PROJECT NAME: TAMLIN RV STORAGE  
 PROJECT ADDRESS: 5080 TAMLIN ROAD, COLORADO SPRINGS, COLORADO 80923  
 PROJECT DESCRIPTION: DEVELOPMENT PLAN

DATE PREPARED: AUG 28, 2024  
 DESIGNED BY: GEM  
 CHECKED BY: WFG  
 REVISIONS:

SHEET TITLE:  
 LANDSCAPE PLAN

Add case number PPR2437

LS1.0

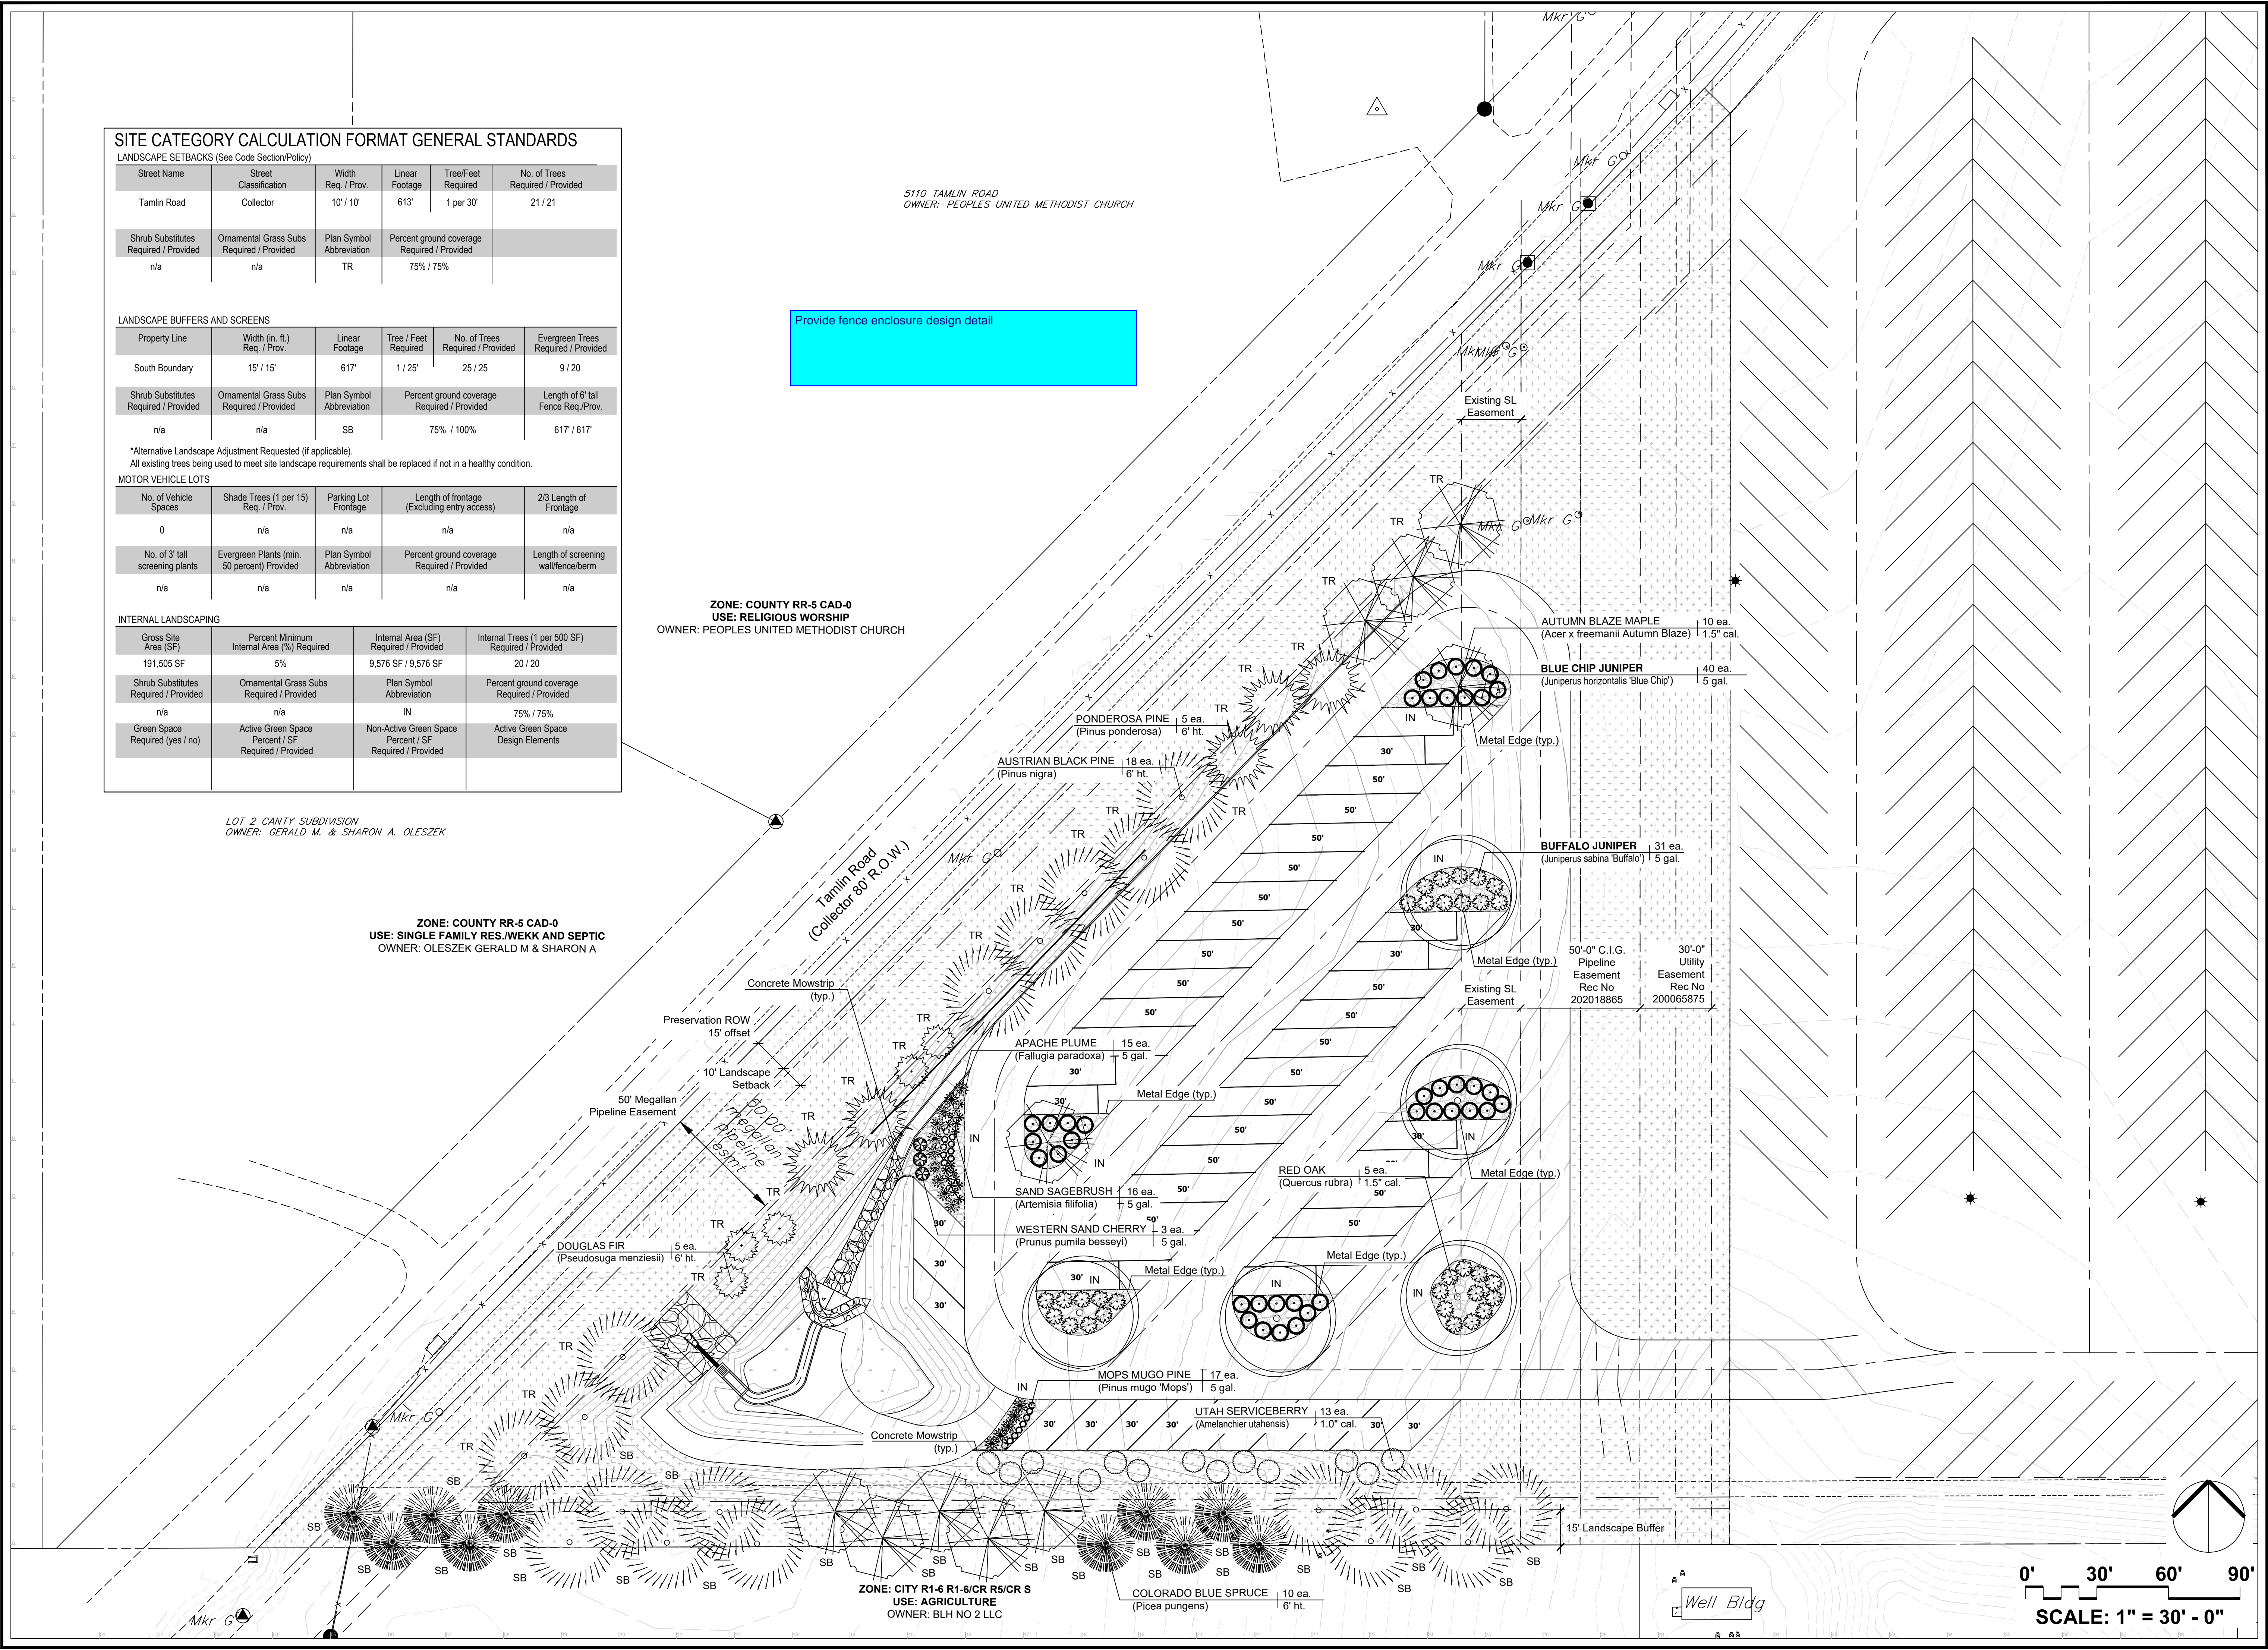
Identify and provide detail with height of new landscape wall
